From: Laura Gibbons <Laura.Gibbons@arun.gov.uk>
Sent: 11 January 2022 11:11
To: Planning.Responses <Planning.Responses@arun.gov.uk>
Cc: Maria Tomalova <Maria.Tomalova@arun.gov.uk>
Subject: Y/183/21/DOC- Pollards Nursery Lake Lane Barnham PO22 0AD

Engineers Comments Regarding Conditions 5 and 6

GRAVEL SURFACE SECTION
(NTS)

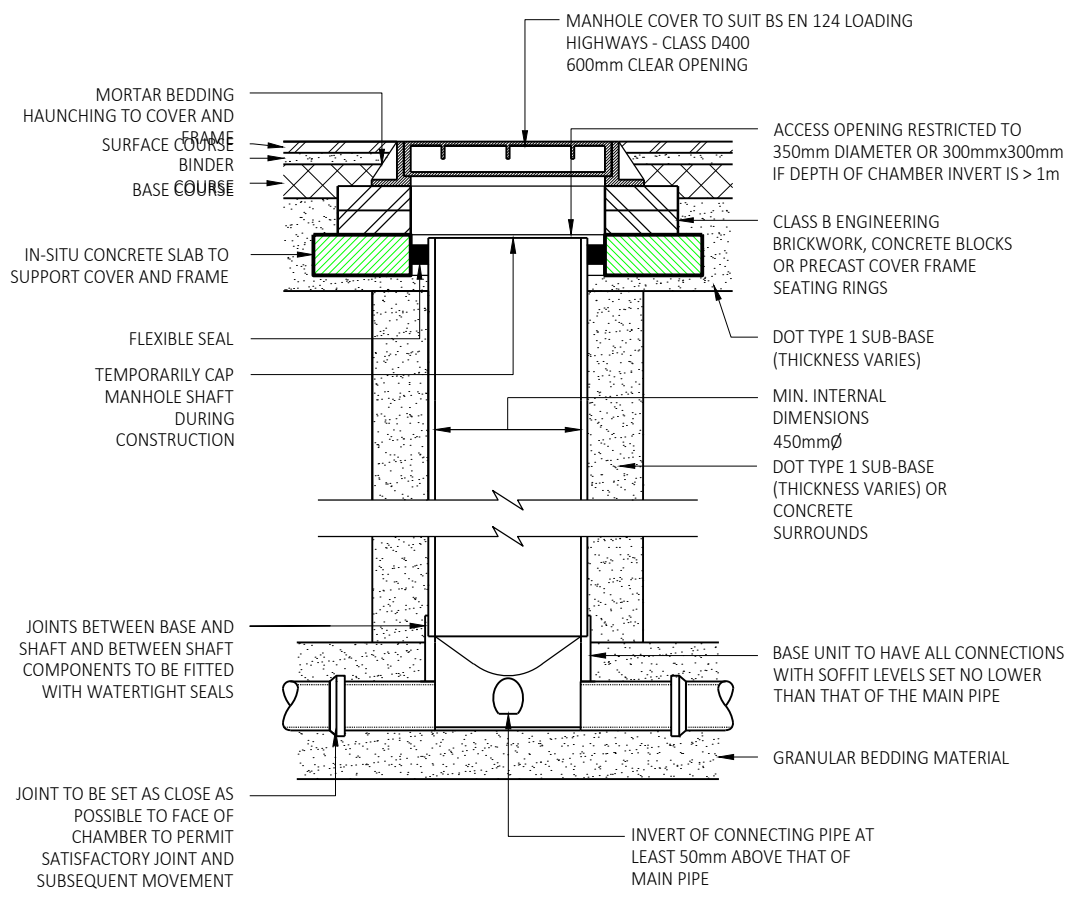
The gravel surface section shows 200mm of sub-base. Rather than the 500mm shown on layout plans, please correct to be consistent.
